Our Case Number: ACP-323873-25

Re: Kingston Park and Millers Lane - Public Park Urban Realm Project
Kingston Park & Millers Lane, County Galway

Re: Proposed Sports & Community Development, Millers Lane, Galway City

Executive Summary – Key Issue: Pavilion Siting and Height

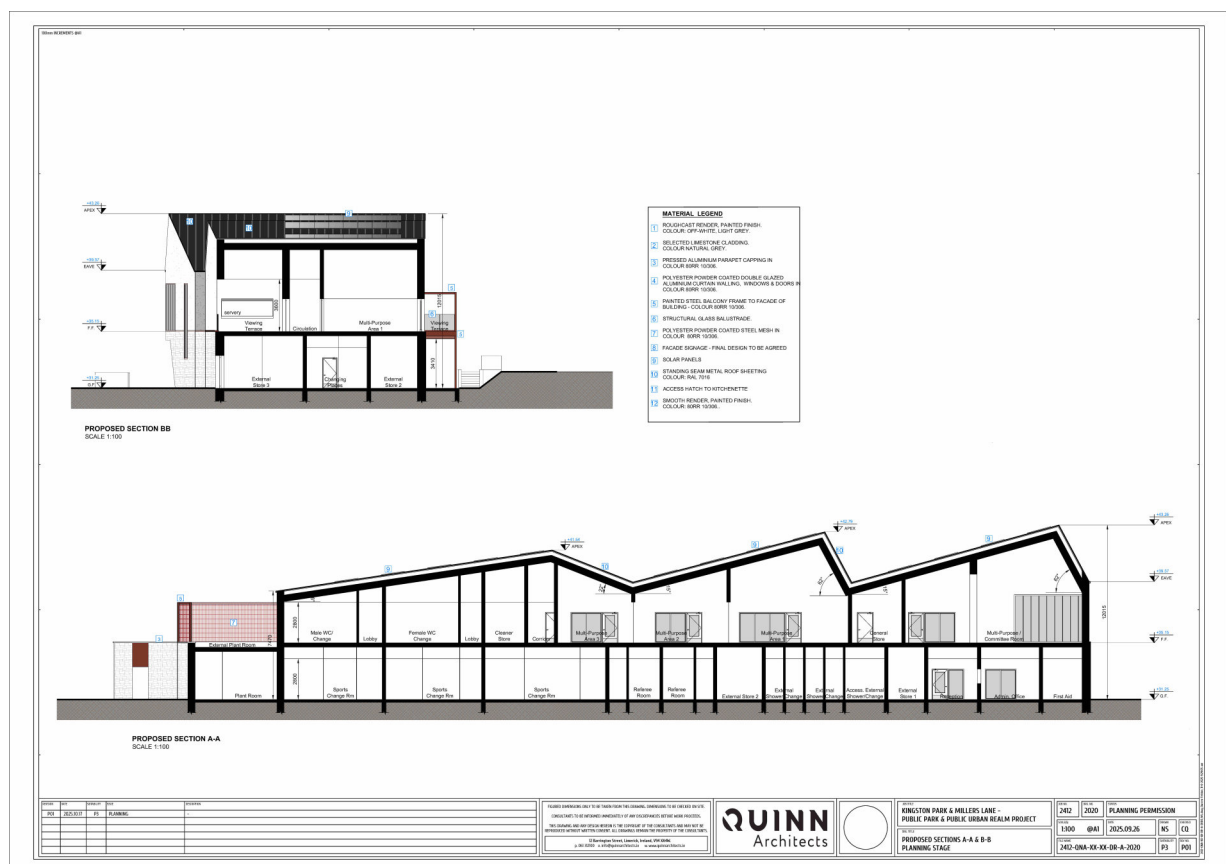
Despite the site being enclosed on three sides by established residential estates, the pavilion has been positioned centrally within the park and tight to rear residential boundaries, rather than along the road frontage where it could be appropriately accommodated within the urban structure.

At a separation distance of approximately 40 metres, the **height alone** is unacceptable. A two-storey building incorporating viewing terraces, internal activity spaces and congregation areas fails to respect the established residential context, particularly where all affected rear gardens directly face the development.

The drawings (ref. A-2040) do not clearly demonstrate that the equipment store will remain below the height of the existing boundary wall directly behind my home.

- relocation of the pavilion to the road frontage
- reduction in building height
- removal of all ancillary and servicing structures from residential boundaries
- omission of the smoking shelter and bin store at residential interfaces
